# A303 Amesbury to Berwick Down

**Deadline 2**  
**8.9 Statement of Common Ground – Winterbourne Stoke Parish Council**

**STATEMENT OF COMMON GROUND – Winterbourne Stoke Parish  
Council**

<b>Version</b>	<b>Date</b>	<b>Status of Version</b>
Rev 0	03.05.2019	Deadline 2 Issue

Drawing Title
**RIGHTS OF WAY AND ACCESS
PLANS
REGULATION 5(2)(k) & 5(2)(o)
SHEET 5 OF 15**

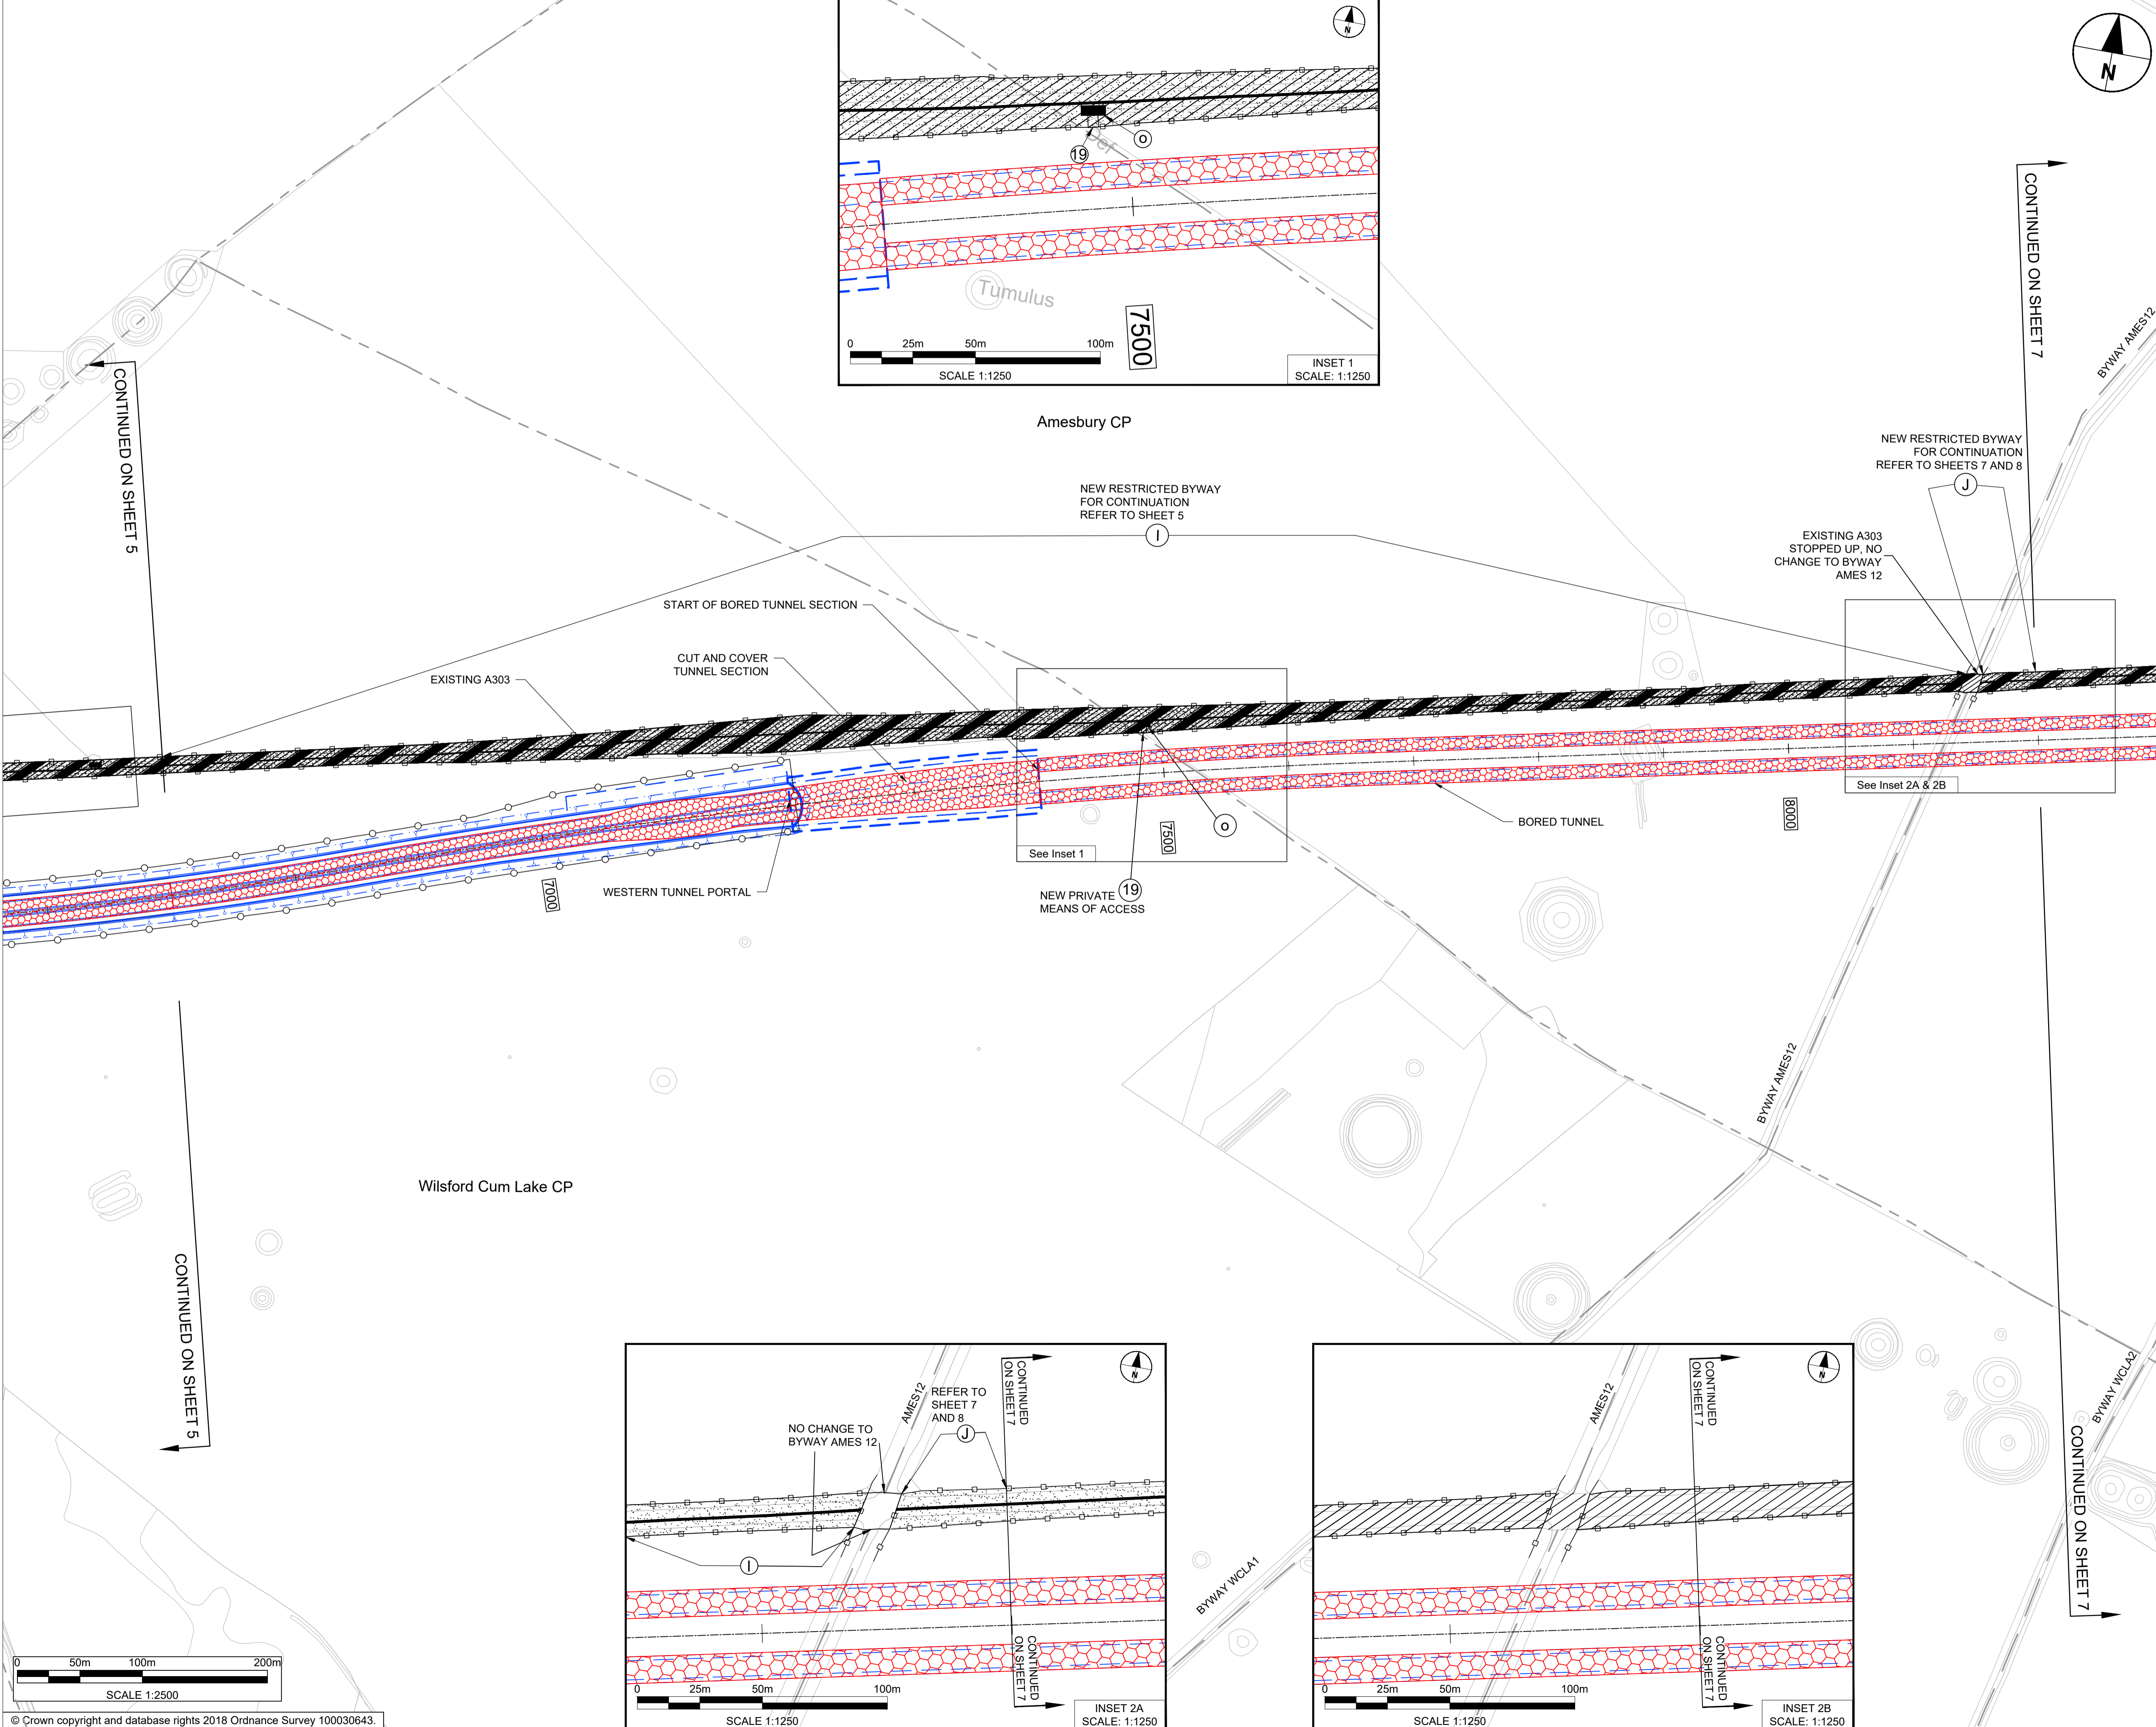
3.11	Longbarrow Junction and Agricultural Impact: access	-	Safe access should be provided to the fields to the east of the new Longbarrow roundabout and lying north and south of the new A303 and west of Green bridge No 4.	Private means of access to fields north and east of the new Longbarrow Junction would be provided and are shown on the Rights of Way and Access Plans [APP-009], sheets 5, 14 and 15.	Agreed
